### **MANDALONG SOUTHERN EXTENSION PROJECT (SSD 5144)**

Thank you for the opportunity to respond to the Environmental Impact Statement (EIS) for Mandalong Southern Extension Project, Council's comments are as follows:

G:\Drafting\Mandalong\CCC14-009\Figures\Final\CAD\FINAL FIGS EB Report\MANDALONG EIS FIGURES\CAD (2nd External Review)\Fg9_CCC14-009_SurfHydrology_V4.dwg

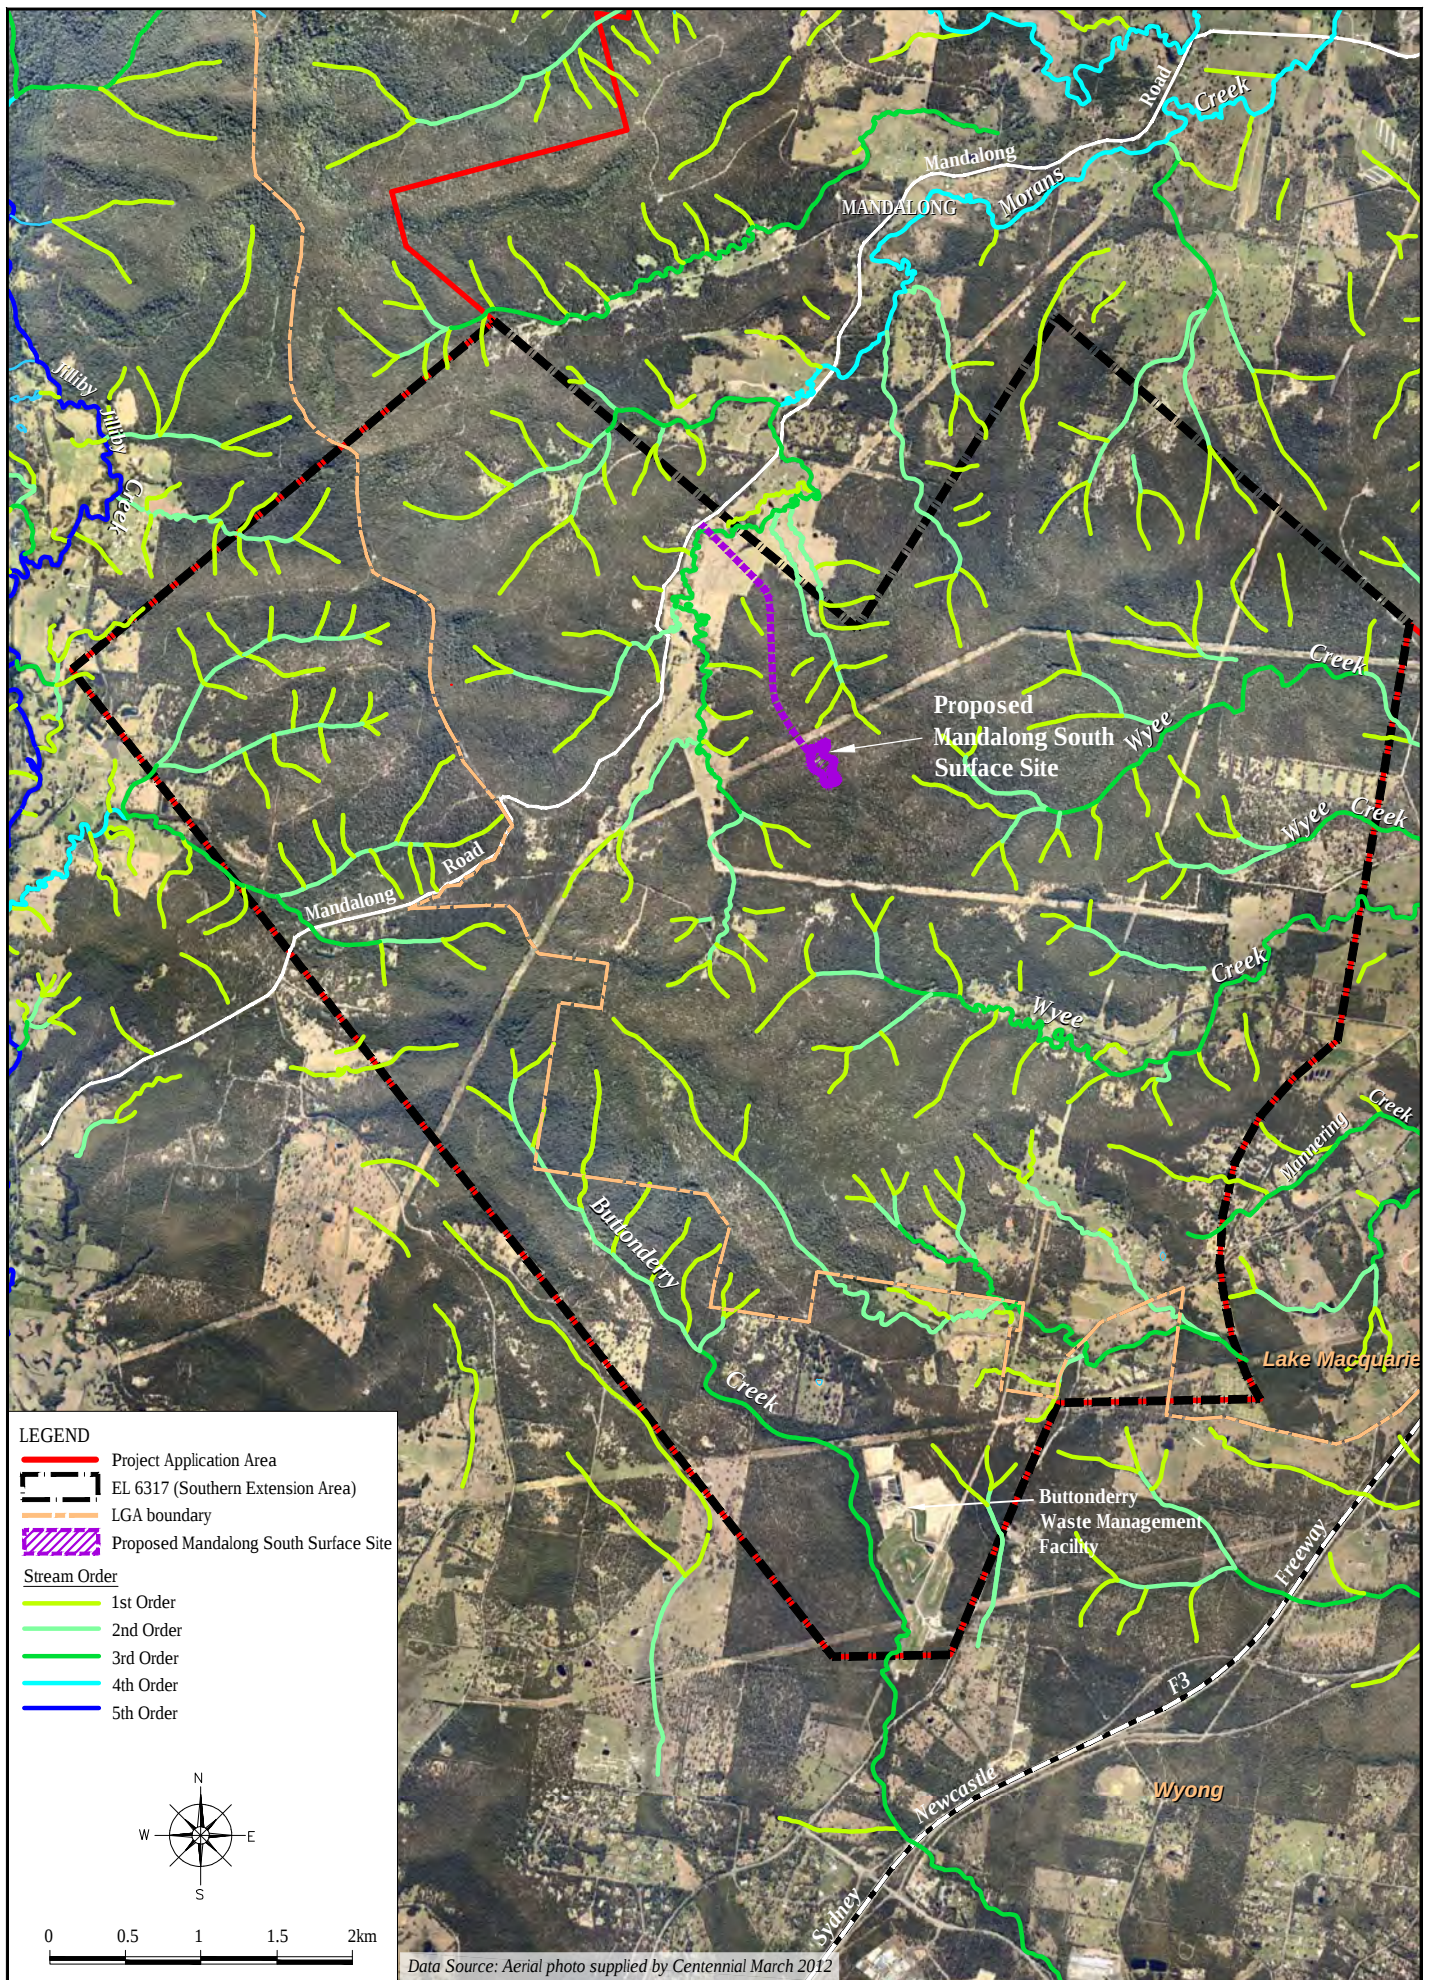
- Both the Flora and Fauna Assessment and the Subsidence Predictions Assessment refer to 4th order streams being present within the study area/above proposed mining area, yet Figure 9 of the EIS does not show any 4th or higher order streams within the study area. Have the potential/predicted impacts being correctly applied to the various streams (threatened species habitat) within the study area?
